Project Name: **Salvation Army Kitchen and Dining Hall Addition to Rehabilitation Center**
Project ID: #2016-016
Address: 88 Preble Street
CBL: 33/D/4-11, 15, 22-26
Applicant: Major Ronald Bernardi, The Salvation Army
Planner: Jean Fraser

On October 4, 2016, the Planning Authority approved with conditions a Level II site plan for the construction of a 4,217 sq ft addition for a new kitchen and dining hall at the Salvation Army Adult Rehabilitation Center at 88 Preble street. The decision is based upon the application, documents and plans dated 9.9.2016 and submitted by the applicant and prepared by Walsh Engineering Associates, Inc and Bild Architecture. The proposal was reviewed for conformance with the standards of Portland's site plan ordinance.

① PHOTOMETRIC PLAN  
SCALE: 3/16"=1'

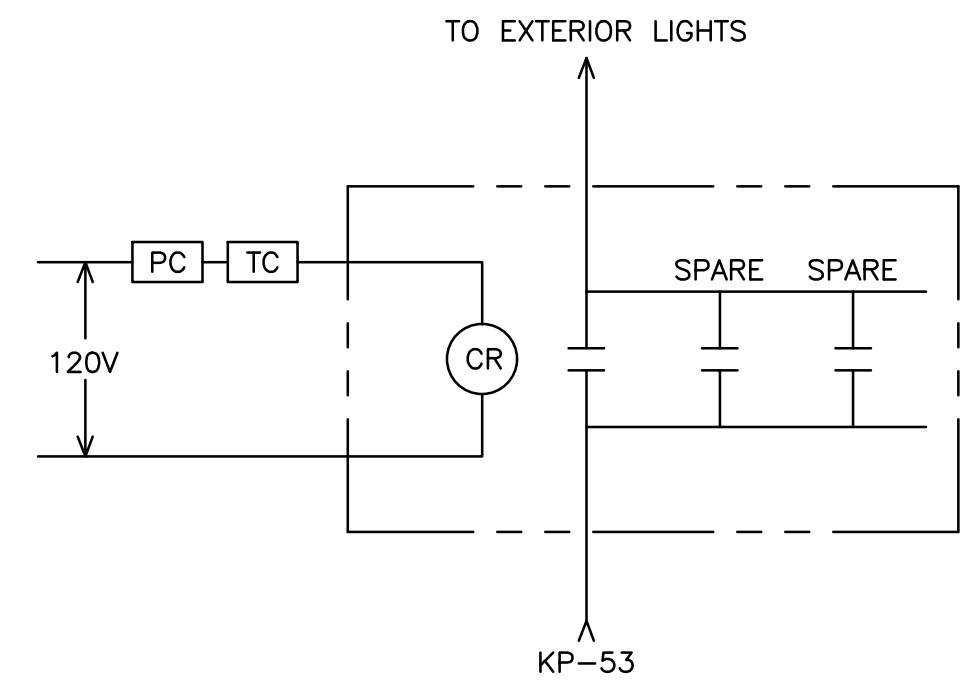
- iii. That the applicant shall submit details of the proposed external lighting, both wall mounted and freestanding, with associated catalog cuts, pole heights and an associated photometric plan to demonstrate compliance with the City's *Site Lighting Standards* in Section 12 of the Technical Manual, for review and approval by the Planning Authority prior to issuance of a building permit; and
- iv. That separate permits from the Permitting and Inspections Department shall be required for any new or revised signage.

ISSUE DATE 2/2/17
SHEET TITLE Site Layout and Utility Plan
SHEET SCALE 1" = 10'

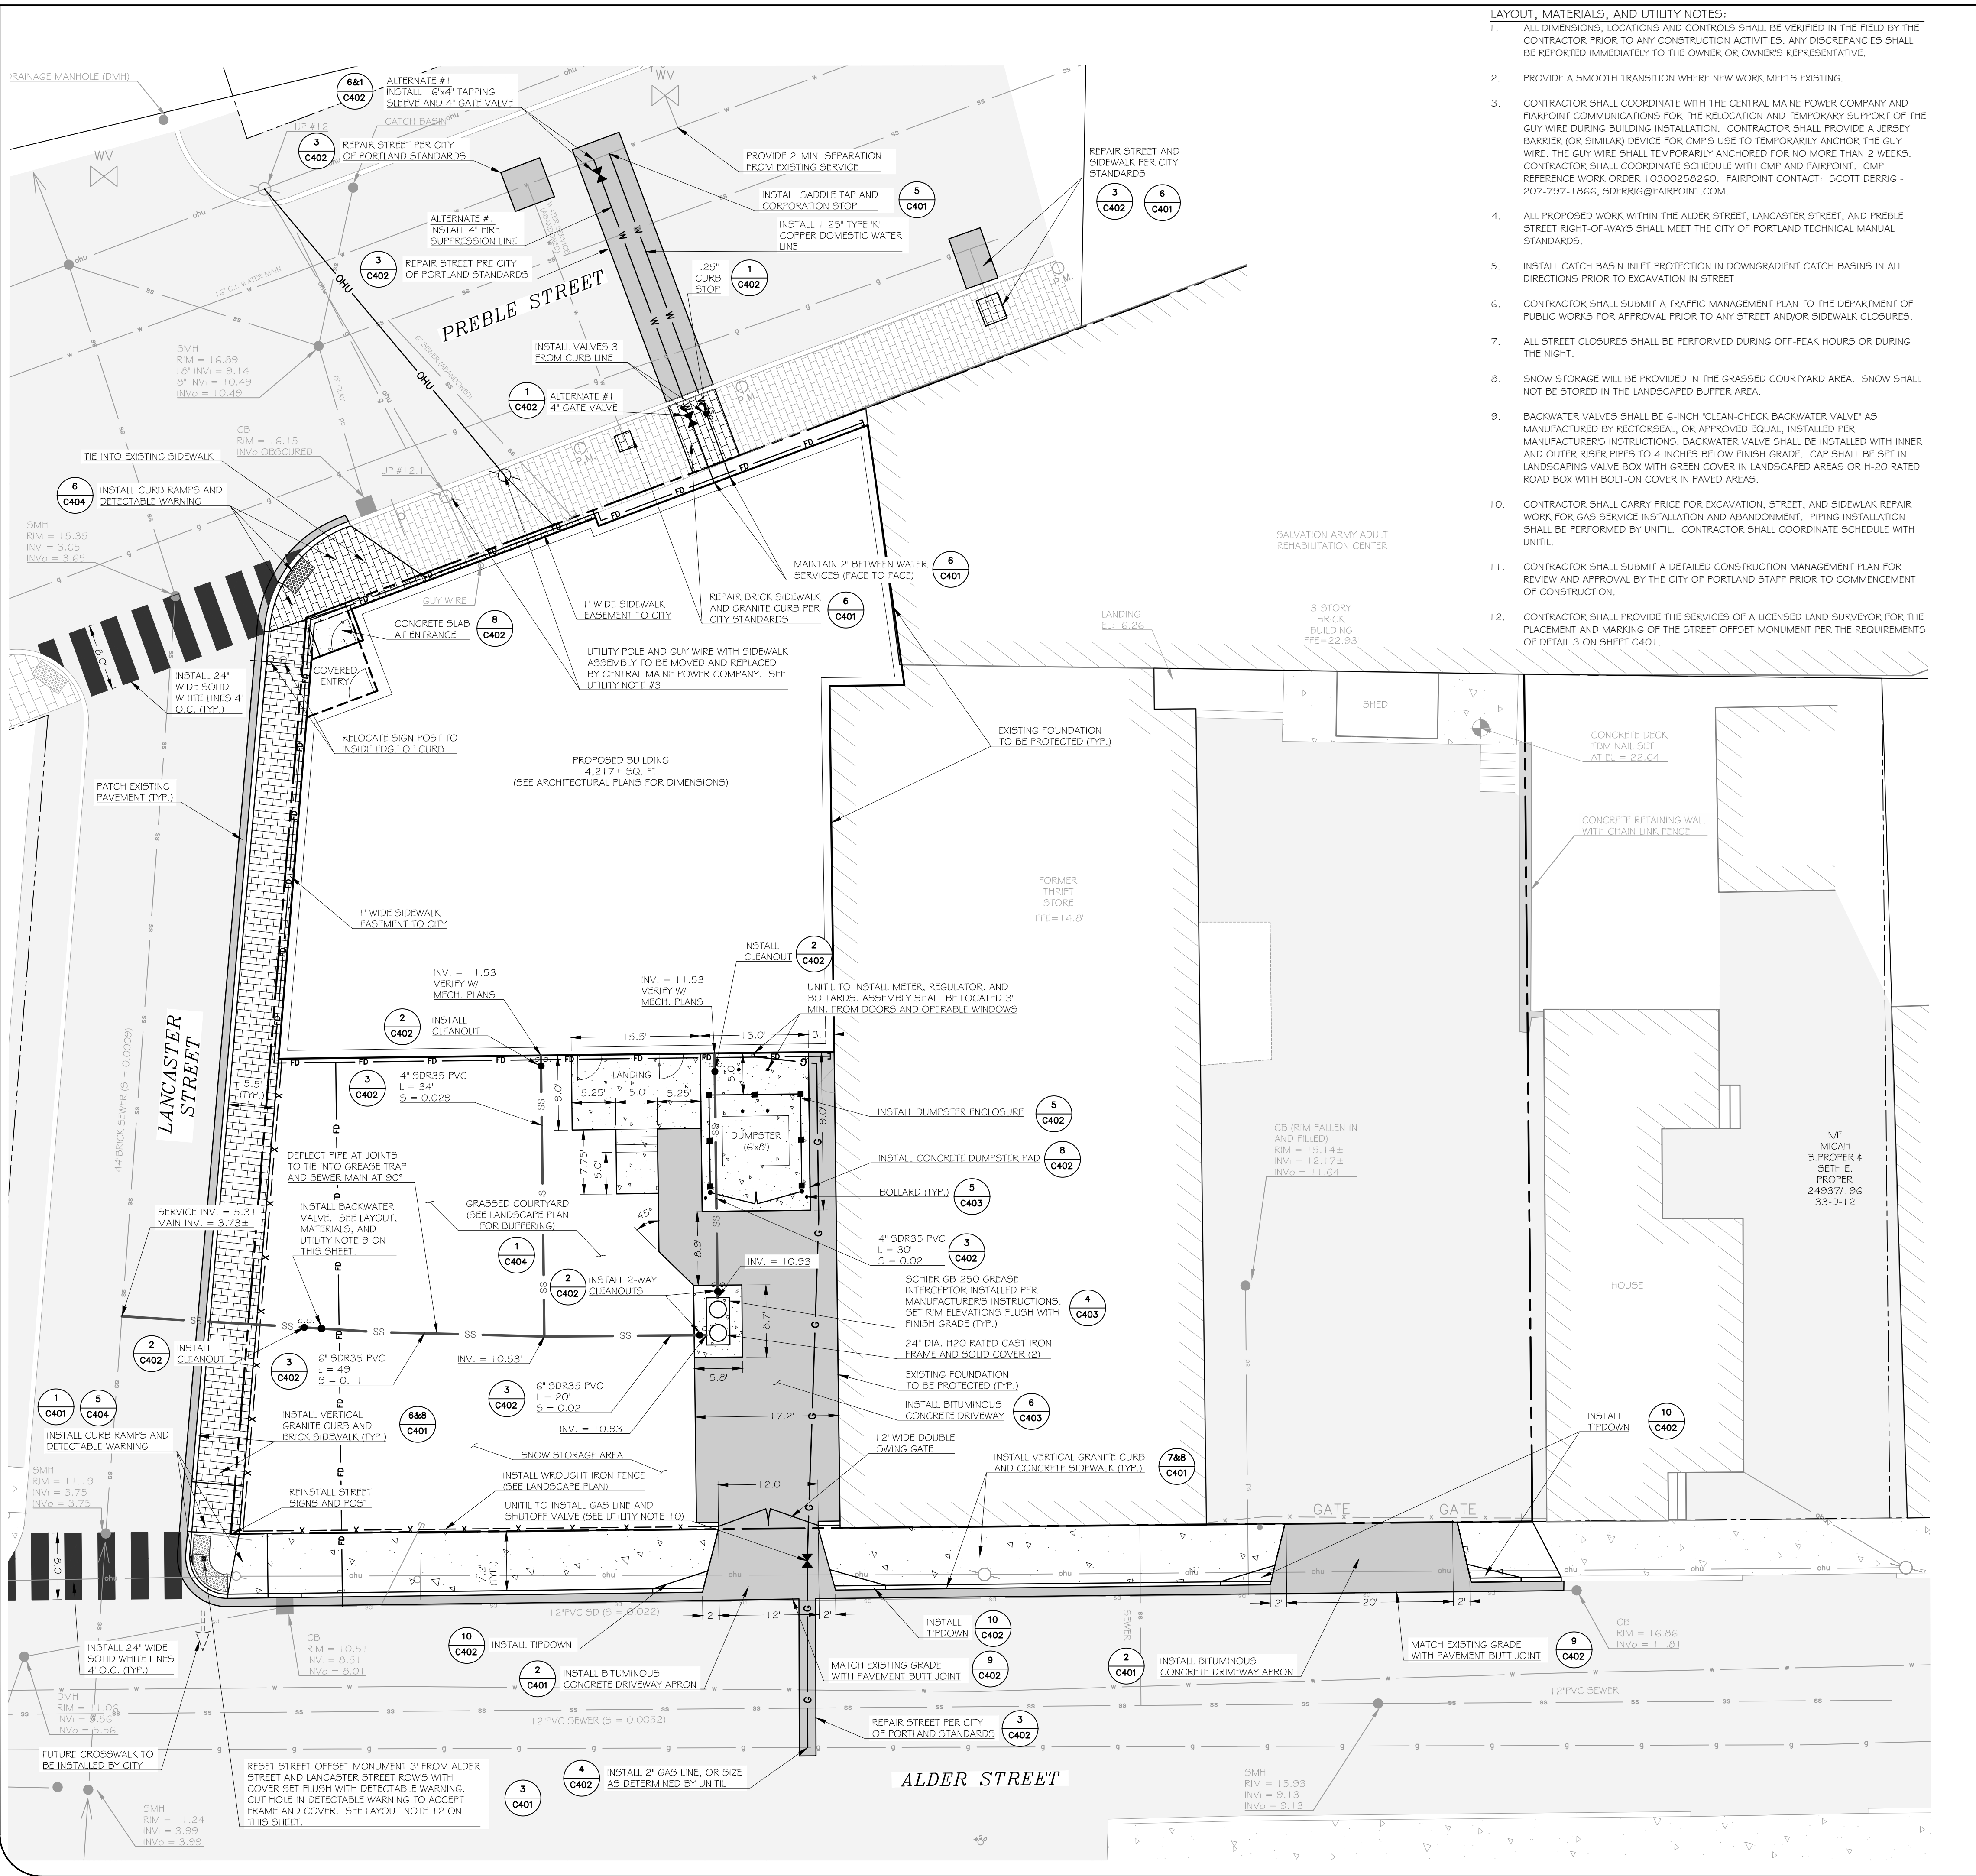
The Planning Authority waives the Technical Standard, Section 1.14 and associated figures, which specify aisle widths and parking space dimensions, to allow the parking aisle widths as approved in Plan C200 in view of the site constraints.
